Our Ref: **SID-DCC-2022-009 Railway Order Dart + West**

28 October 2022

**Proposed Strategic Infrastructure Development (SID): Planning Application Ref NA29S.314232 by Coras Iompair Éireann (CIE) for Railway Order for the Dart + West project - operation, maintenance and improvement of the railway along an approximate 40km section of the existing railway line between Dublin City Centre and the M3 Parkway Station (County Meath) and a new maintenance depot to the west of Maynooth (County Kildare).**

Area No: 016 Plan No: WORKS LAYOUT PLAN NO. WP016

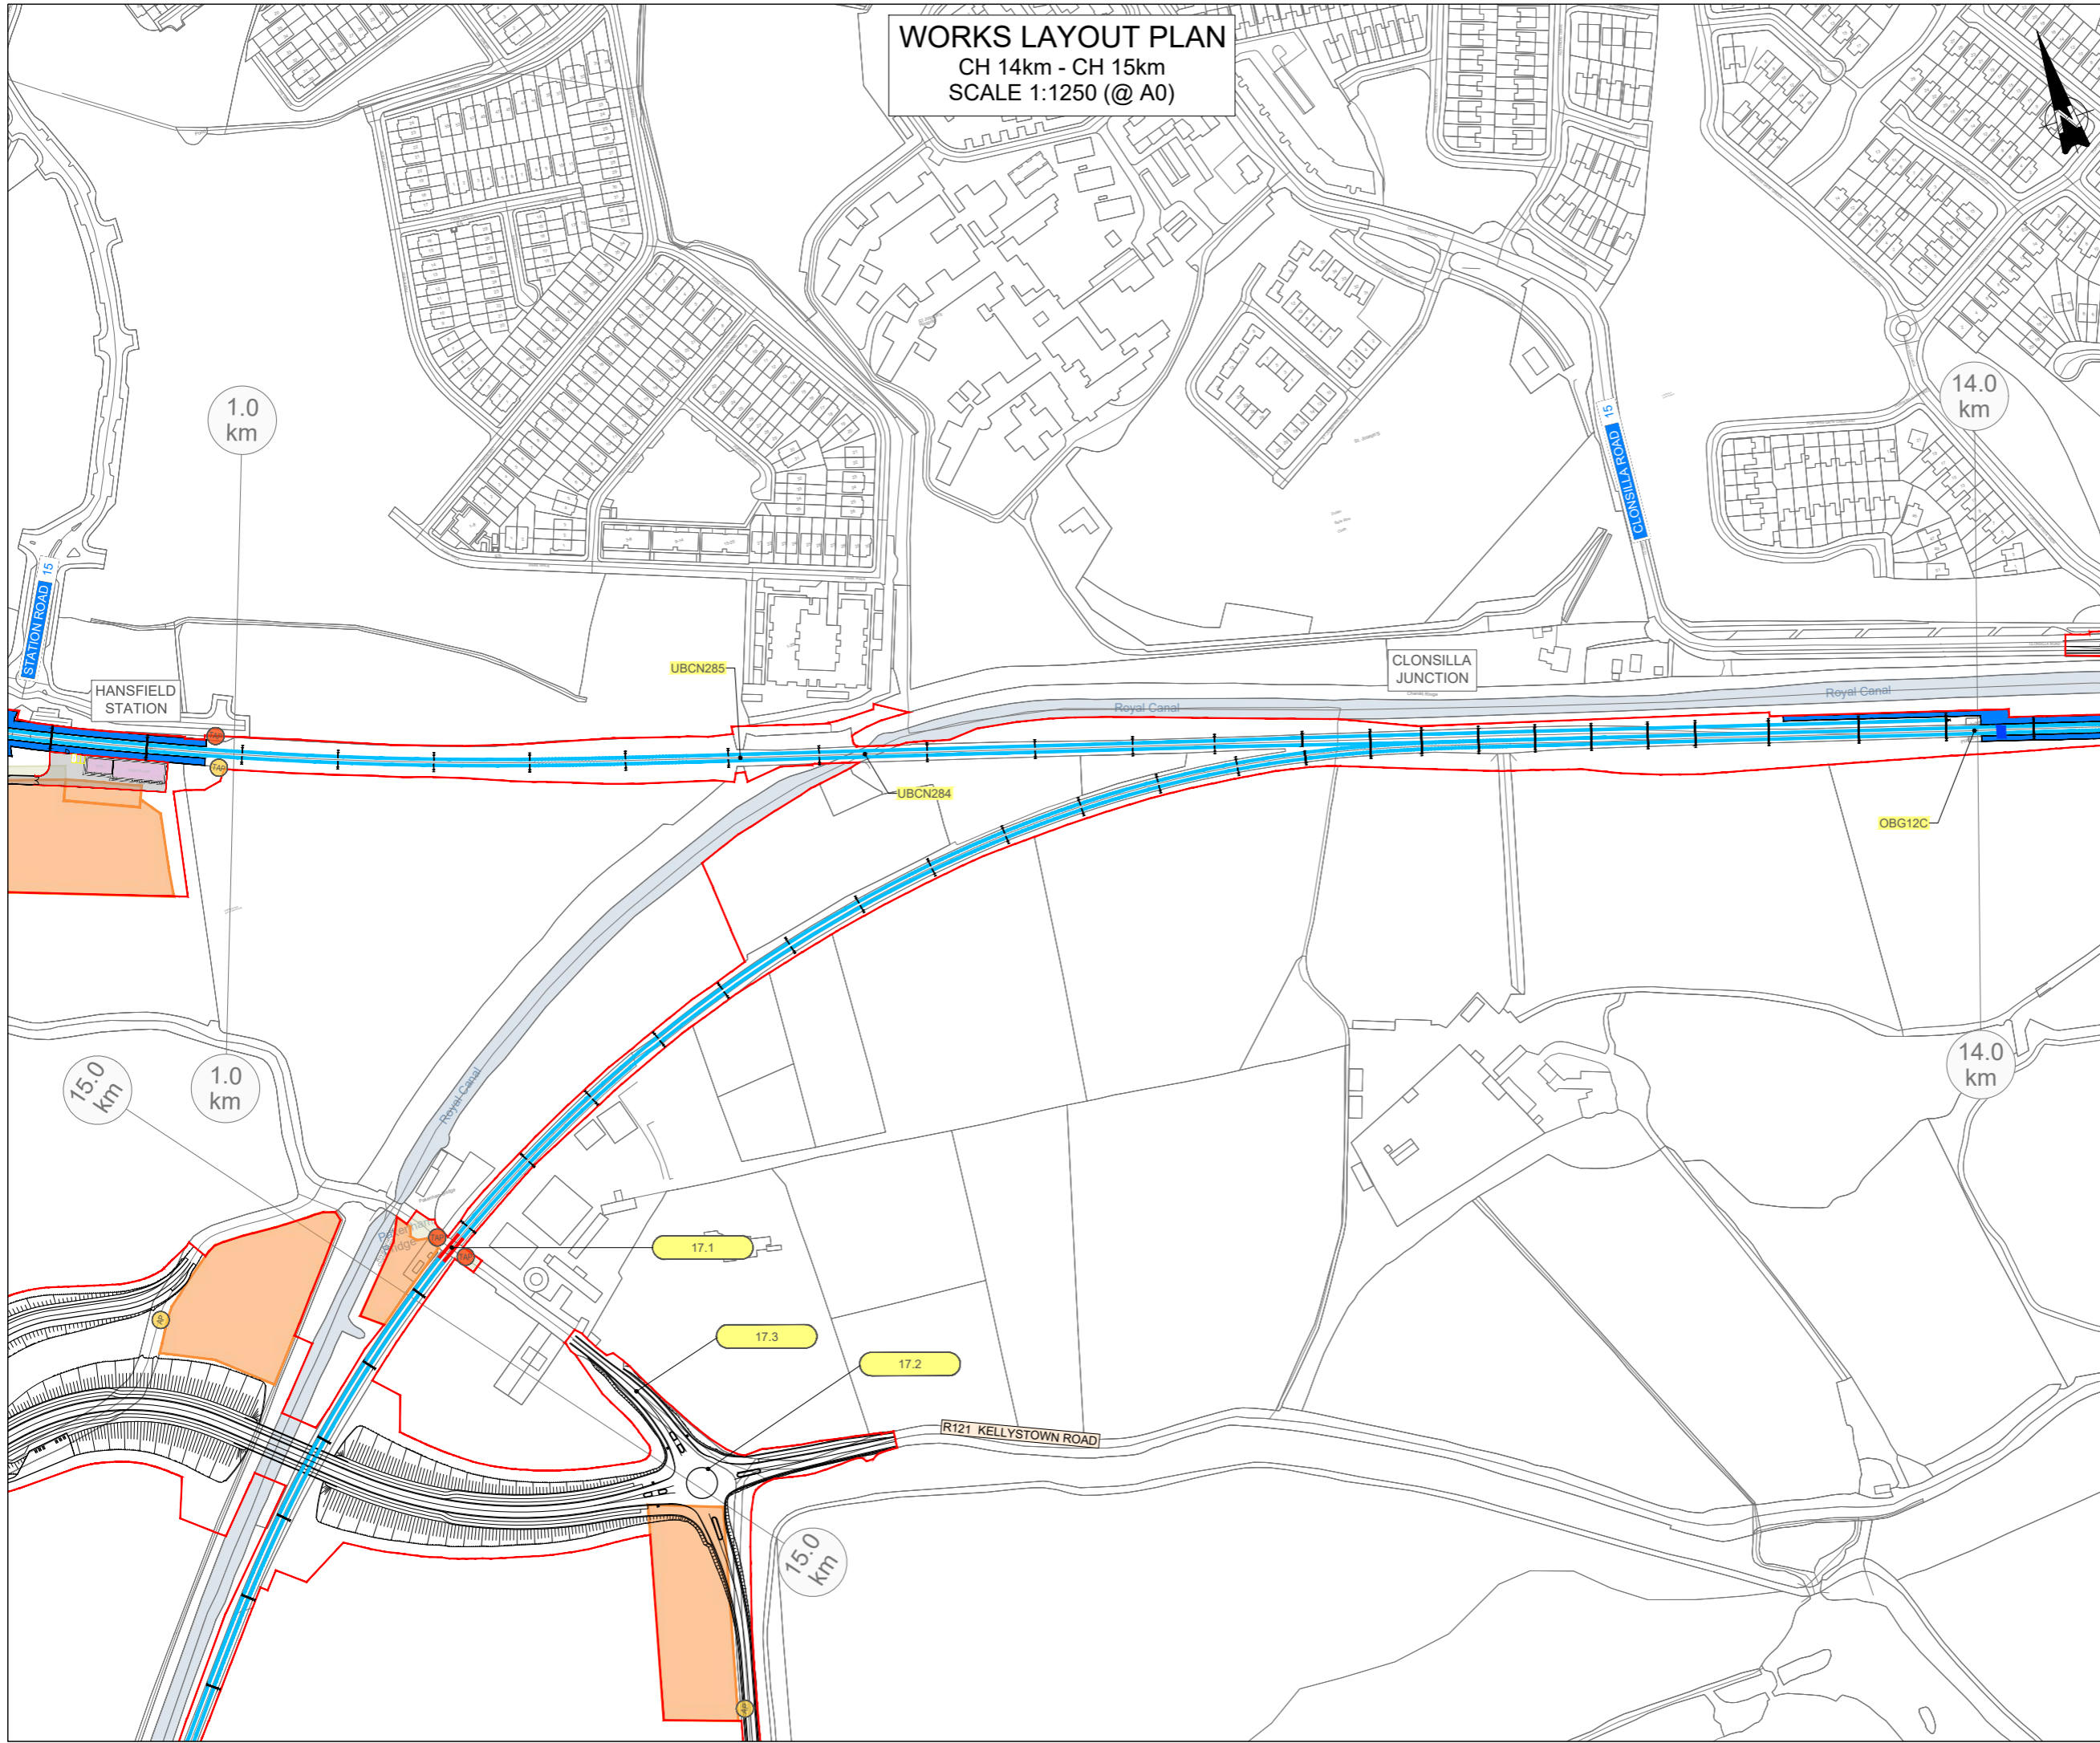
**2) Direct impact of siting of construction compound (Compound Code: CC-PW-S5-59970-B)**

Works Layout Plan No WP16 shows a proposed construction compound (Compound Code: CC-PW-S5-59970-B) to be located south of the rail line at Clonsilla and east of the Clonsilla Road. Recorded Monument DU013-018---- (Barrow – ring-barrow) is located centrally within the zone for this compound and occupies a substantial footprint within that zone. It is not clear if Chapter 20 of the EIAR has fully accounted for this in assessing the likely impacts to Recorded Monument DU013-018---- (Barrow – ring-barrow). The proposal to site a construction compound at this location appears to materially conflict with the measures necessary to preserve and protect the Recorded Monument during all stages of construction works (i.e. the implementation of an adequate Exclusion Zone to buffer the site from any and all direct impacts). If protection of the monument cannot be guaranteed, then the compound must be relocated.

5. In advance of the commencement of any construction works, a Management Plan for RMP DU013-018---- (Barrow – ring-barrow) shall be prepared and implemented following consultation with and approval by this Department and the planning authority.

- a. The plan shall provide for the management of RMP DU013-018---- (Barrow – ring-barrow) to ensure that preservation in situ of the site can be achieved and maintained.

- c. The plan shall be informed by the Archaeological Geophysical Survey of AAP14.
  - d. The plan shall define appropriate Exclusion Zones to ensure that RMP DU013-018---- (Barrow – ring-barrow) shall remain secure and preserved *in-situ*. Exclusion Zones shall be fenced off for the duration of construction

works in the vicinity of the monument. No groundworks of any kind (including but not limited to advance geotechnical site investigations) and no machinery, storage of materials or any other activity related to construction will be permitted within Exclusion Zones.
